Our Ref: EN010141/DR/8.37

Application Reference: EN010141

Applicant Cover Letter for Virtual Site Inspection Plan (Final)

I write on behalf of BSSL Cambsbed 1 Ltd (the 'Applicant') in relation to the **Virtual Site Inspection Plan [REP2-046]** submitted by the Applicant at Deadline 2.

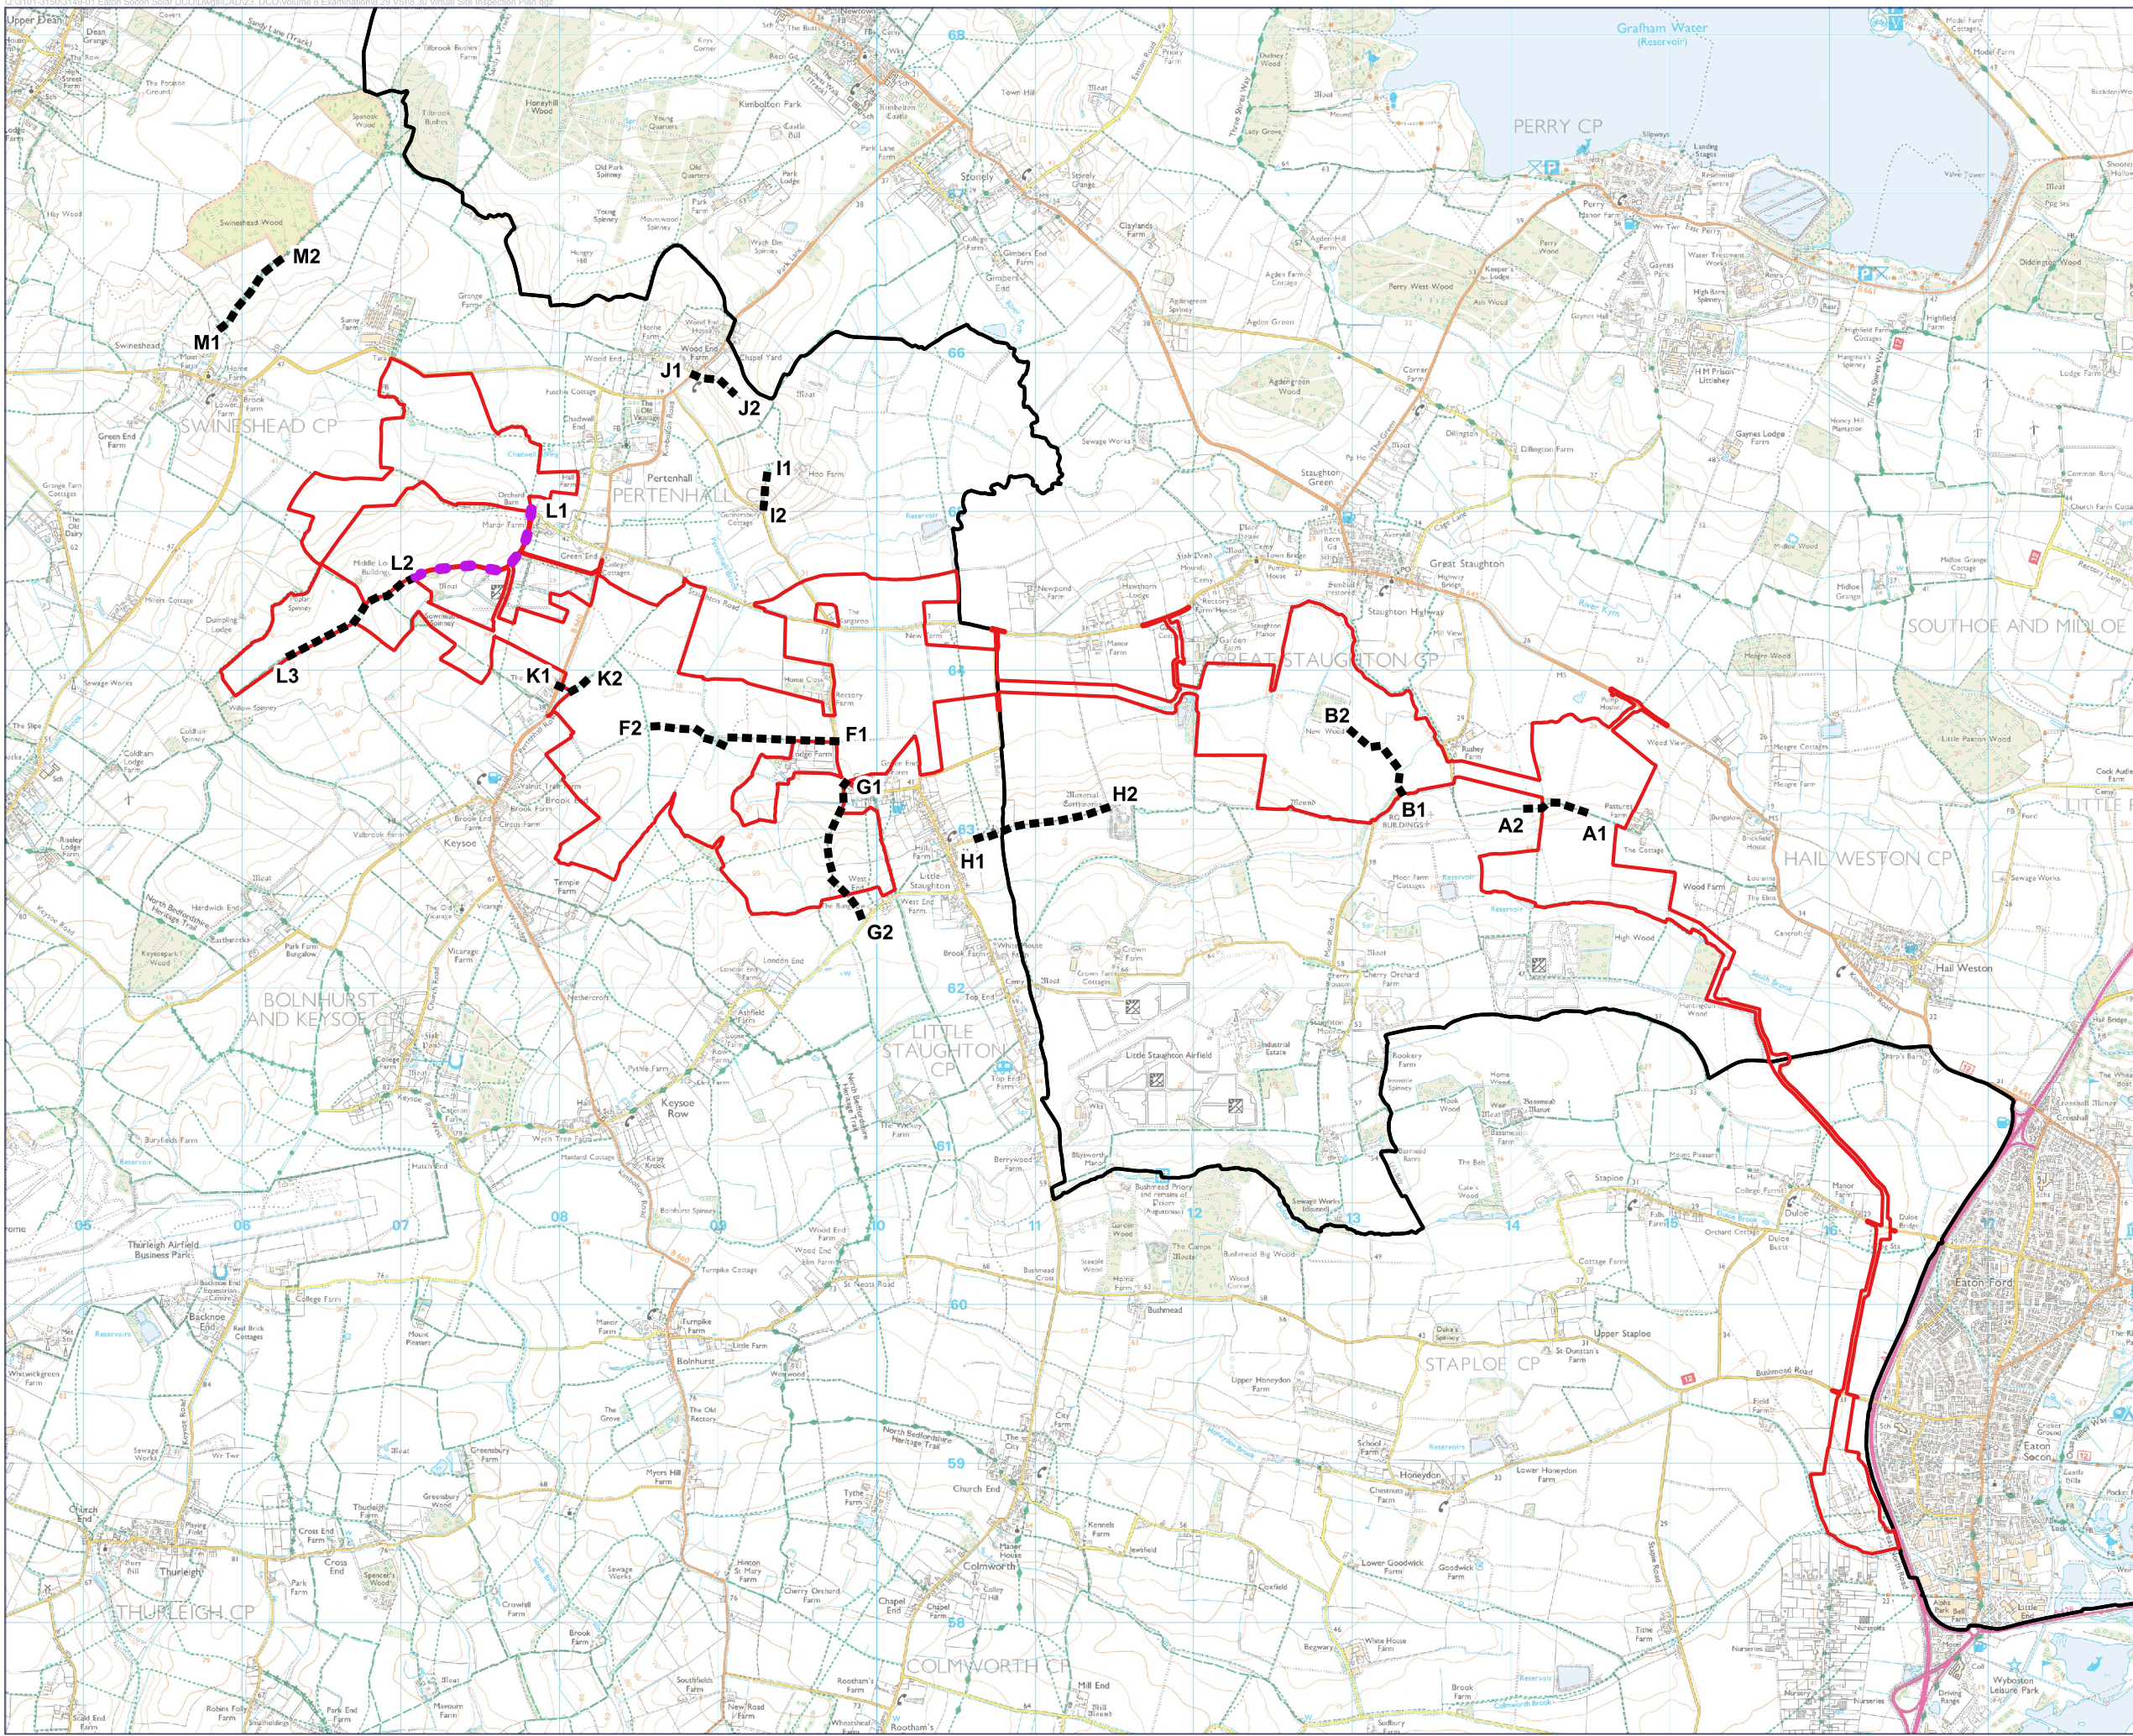
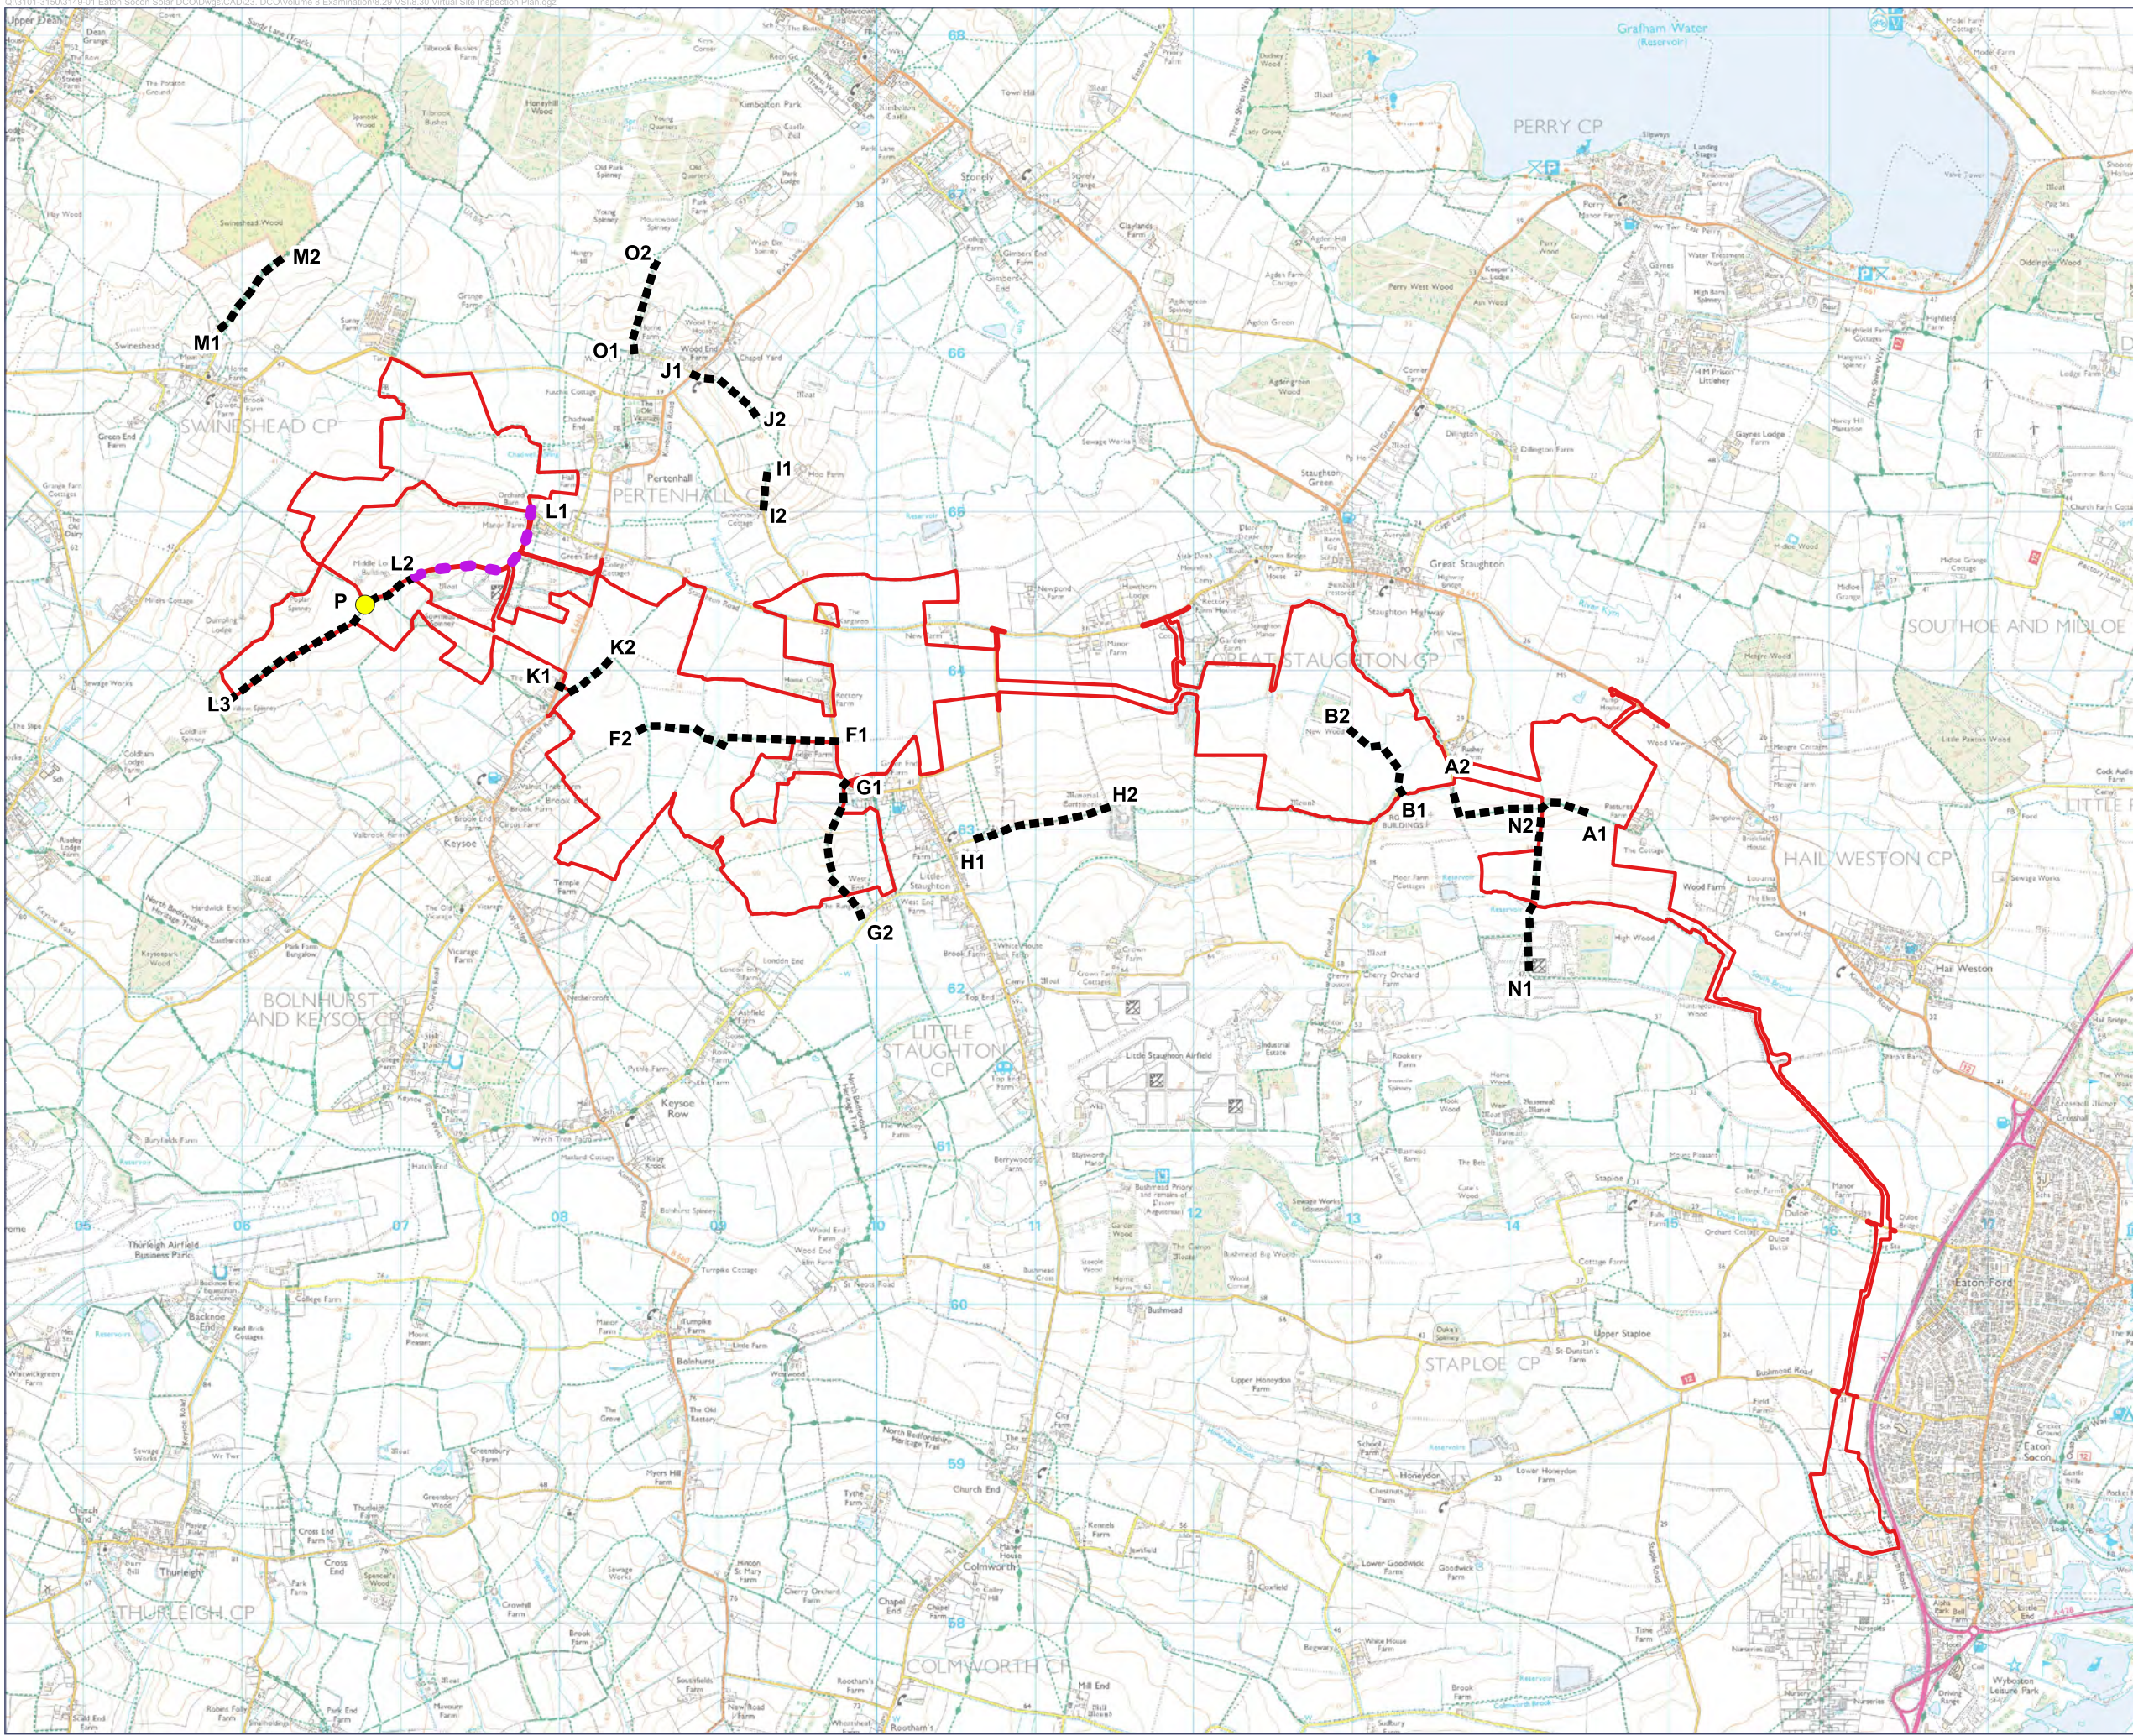
Interested Party	Examination Library Reference	Comment	Applicant Response
British Horse Society (Bedfordshire)	REP3-088	In our response to the draft ASI itinerary (REP2-060), we asked that what is now Survey Route 9b should be extended to the western end of the site. The western most point in the virtual Survey Route is a bit further along the route than was originally proposed but the whole route is still not being covered. We ask that point L3 is moved to the far end of the site, to what is viewpoint 9 in the LVIA.	The Applicant has made this amendment, as shown on Figure 1 of the final Virtual Site Inspection Plan.
British Horse Society (Bedfordshire)	REP3-088	At 2.2.1, it is proposed that the footage will be captured at, or as close as practicable, to typical human eye level. This is of course ideal for representing the experience of walkers on the PRoW and probably cyclists as well. But equestrians’ eyes are at a greater height (typically between 7 and 8 foot above ground, depending on the size of both horse and rider). The Society asks that the recording for the surveys along bridleways should be at that height (ideally in addition to the walker height recordings). This is particularly relevant for Survey Route 9b, where we consider that the experience of a rider will be significantly different from that of a walker/cyclist.	The Applicant has made this amendment and is proposing to capture the 360 footage from Digital Survey 9b from approximately 2.5m (just over 8 foot) above ground level, noting that this is generally accepted as the average height of a horse and rider.

Borough of Bedford Local Access Forum	REP3-084	The ‘crossroad’ junction of B&K FP13 and B&K FP47 within Site B – this is viewpoint 33 in APP-129 and APP-135. This point is close to point F2 at the western end of Survey Route 3. Whilst it may just be a matter of the granularity of the map, it does look as if the Survey will start slightly to the east of the crossroad junction. BOBLAF recommends that the Survey should start just to the west of the junction and that care should be taken to ensure that the views in all four directions at that crossroad are recorded. Ideally, the operator would walk a few feet in either direction on FP13 as well as along FP47.	The Applicant has updated Figure 1 in the final Virtual Site Inspection Plan to make it clearer that Digital Survey 3 will extend west of the ‘crossroad’ junction between B&K FP13 and B&K FP47.
Elaine Wheeler	REP3-094	Route A1-A2 The area should also be viewed from the ground to use the	The Applicant has included ‘Digital Survey 11’ in the final Virtual Site Inspection Plan, which proposes to survey the footpath

Interested Party	Examination Library Reference	Comment	Applicant Response
		footpath up to High Wood which will also show how EPE would join the existing solar installation and one that already has planning permission.	up towards High Wood Solar Farm.
Elaine Wheeler	REP3-094	Point E This area needs to be visited, it is at the crossroads. Heading towards Pertenhall the site is flat and very visibly from the road. It is also a shared access with a sheep farmer.	The Applicant maintains that an additional 360 would be of no benefit, and that the view from the Kangaroo is well represented by LVIA viewpoint 46 [APP-138].
Elaine Wheeler	REP3-094	Route J1-J2 This needs to be extended and walked in person. From here is a view from Birds Egg Farm, across Site A showing how the panels are proposed to go up the lower slopes of the facing ridge, showing how it sweeps behind St Peters church, down towards Green End, Great Staughton Road and the B660 down to Keysoe. It shows how the Brook and the footpath would be entrapped by fencing and panels Only the human eye would show the impact of this and also the proximity to rural houses, several of which are of modest size.	The Applicant included this route as shown by Stop East Park Energy in its suggested Viewpoint 2 [PDA-024]. The Applicant has extended point J2 further east as shown on Figure 1 of the final Virtual Site Inspection Plan.

Elaine Wheeler	REP3-094	Route K1-K2 This is not long enough and again requires on the ground presence, at present this is a relaxing walk for pedestrians away from vehicles on B660 on a grassy footpath. It is the route of the sewer, a consideration for the proposed use of so many HGVs.	The Applicant has extended point K2 further north as shown on Figure 1 of the final Virtual Site Inspection Plan.
Elaine Wheeler	REP3-094	Additional Viewpoint of Importance not mentioned Footpath 14 leading from Wood End Lane. This footpath rises steeply and prior to reaching the hedgerow crossing the site into Cambs. The Inspector should turn and look back the viewpoint will show a	The Applicant has included 'Digital Survey 12' in the final Virtual Site Inspection Plan, which proposes to survey Footpath 14 as suggested.

Stop East Park Energy	REP3-107	Route J1-J2 SEPE submits that this route should be extended and physically walked by the Examining Authority. This location provides important views from Birds Egg Farm across Site A and demonstrates how the proposed arrays would extend up the lower slopes of the opposing ridge and sweep behind St Peter's Church towards Green End, Great Staughton Road and the B660 corridor.	The Applicant included this route as shown by Stop East Park Energy in its suggested Viewpoint 2 [PDA-024]. The Applicant has extended point J2 further east as shown on Figure 1 of the final Virtual Site Inspection Plan.
Stop East Park Energy	REP3-107	Route M1-M2 SEPE considers that views of the proposed development from this location are comparatively limited and therefore does not regard this as an essential location for digital recording.	The Applicant has retained this route, which was requested by Jonathan Hart at Procedural Deadline A [PDA-031].
